The hydrogeological impact assessment is based on assumptions about the nature of the Shepley Spring boreholes and the SPZ. Significant further work and understanding of the baseline is required to outline the risks to the short term and long term operation of the site, and the jobs that will protect. The sensitivity of the abstraction should be 'very high'.

Figure 4-5 Source/ pathways and receptors schematic of the Proposed Development Site

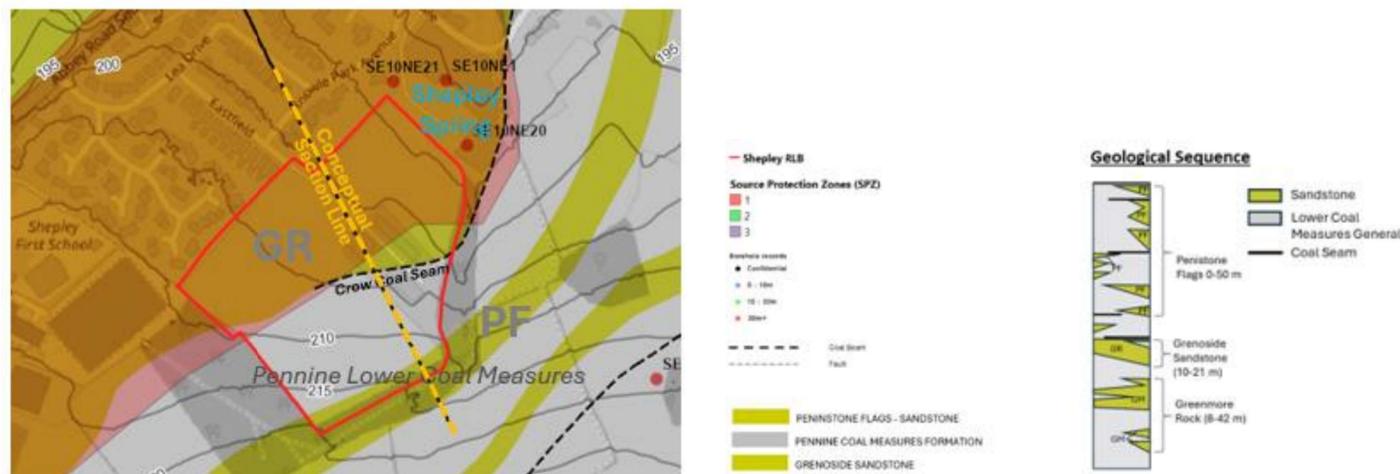
Without knowing the depth of abstractions, and borehole engineering an assessment cannot be made. Age and condition of the abstraction boreholes will be important even if shallow geology is cased out.
